CITY OF ALBUQUERQUE

**Re: Weeping Willow Plaza
Lot 35-A, Block 39, Valley View Addition
5001 Central Ave., NE, Grading and Drainage Plan
Engineer's Stamp Date 9-25-13 (K17/D107)**

C0.1
GRADING PLAN

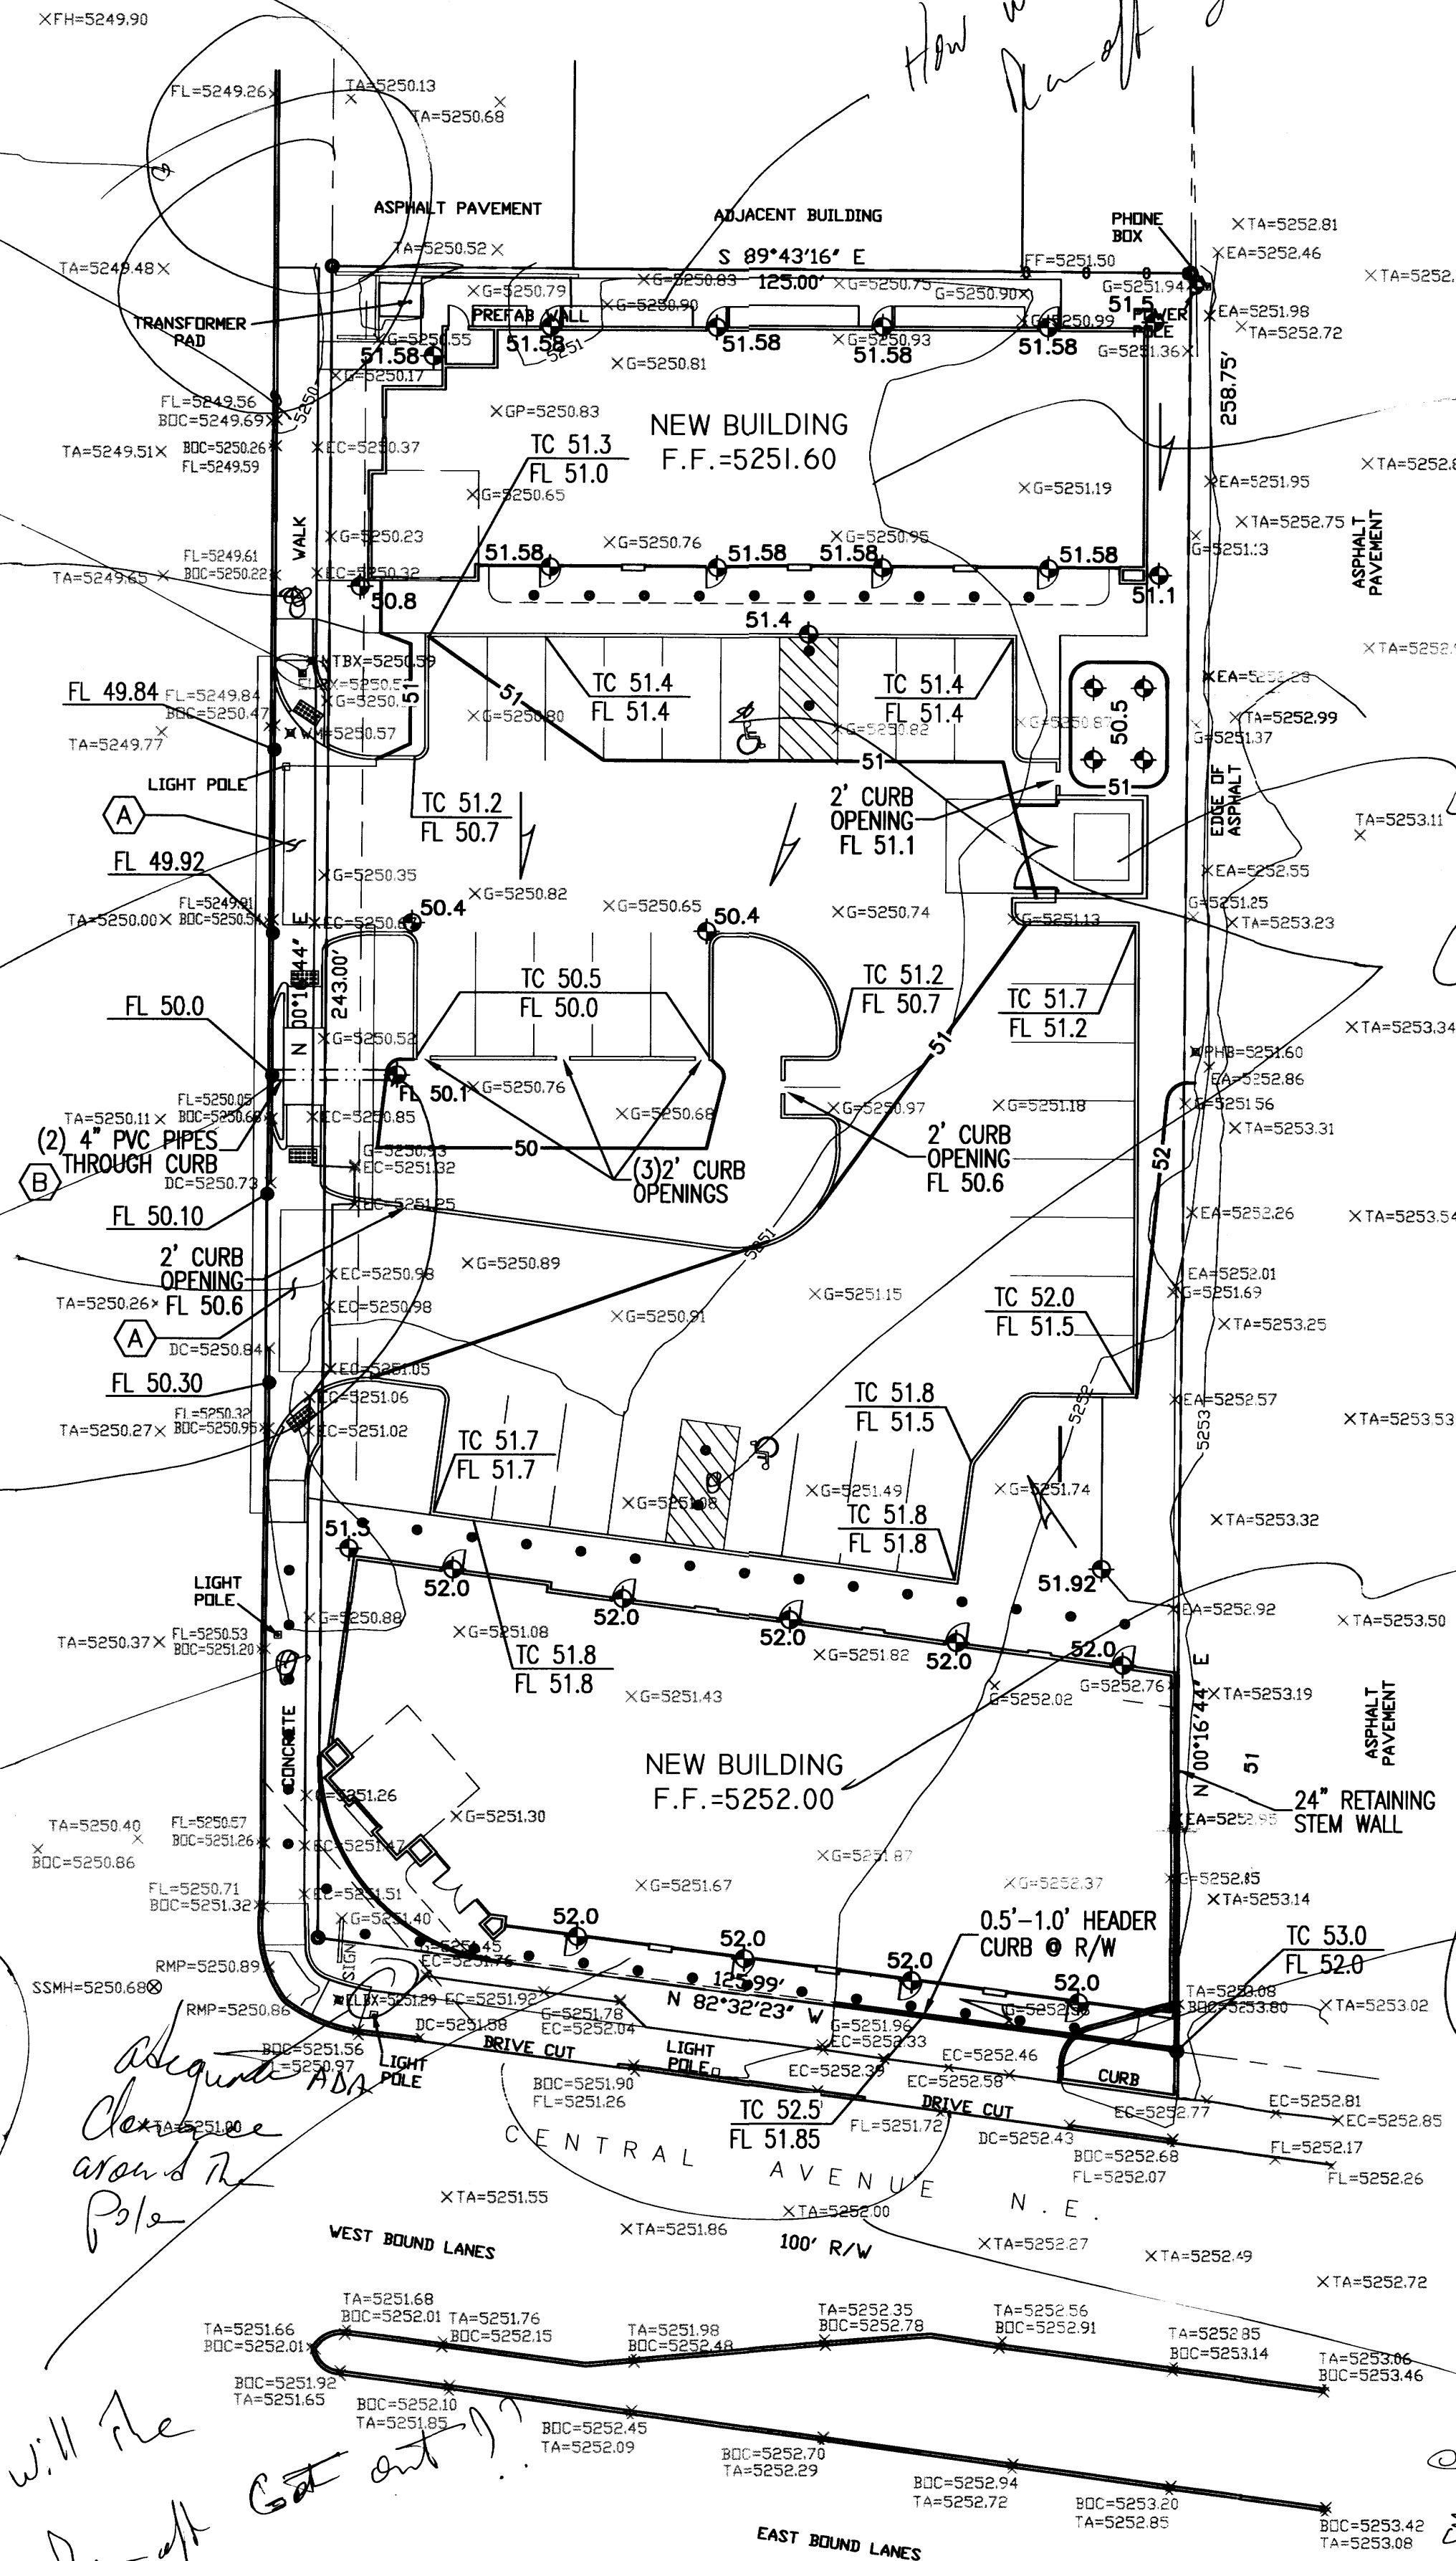
- Are there offsite runoff from the east and the north? How will offsite runoff drain through the site? The southerly building might be blocking offsite runoff.

- The existing entrances not being used have to be removed and replaced with standard curb and gutter. Portion of the existing entrance at the northwest corner of the site will have to be removed. Provide back sidewalk elevations and how they will tie to the proposed doorways. Will all doors be handicap accessible?

- Include roof flow directions. How will the runoff drain north side of the northerly building and south side of the southerly building? There are 2-4" pipe penetration proposed. Will the runoff flow over the sidewalk if the pipes are plugged? Provide more elevations in this area and back of sidewalks along Jackson Street. Will the existing pipe penetration along Jackson Street be removed?

- Do we have adequate water block at the entrances?
- Provide spot elevations within the handicap parking area to assure ADA compliance.
- A drain to the sanitary sewer should be provided for the trash enclosure area if a restaurant is being proposed on this site.

- Clearly show existing versus proposed improvements along the right-of-way.
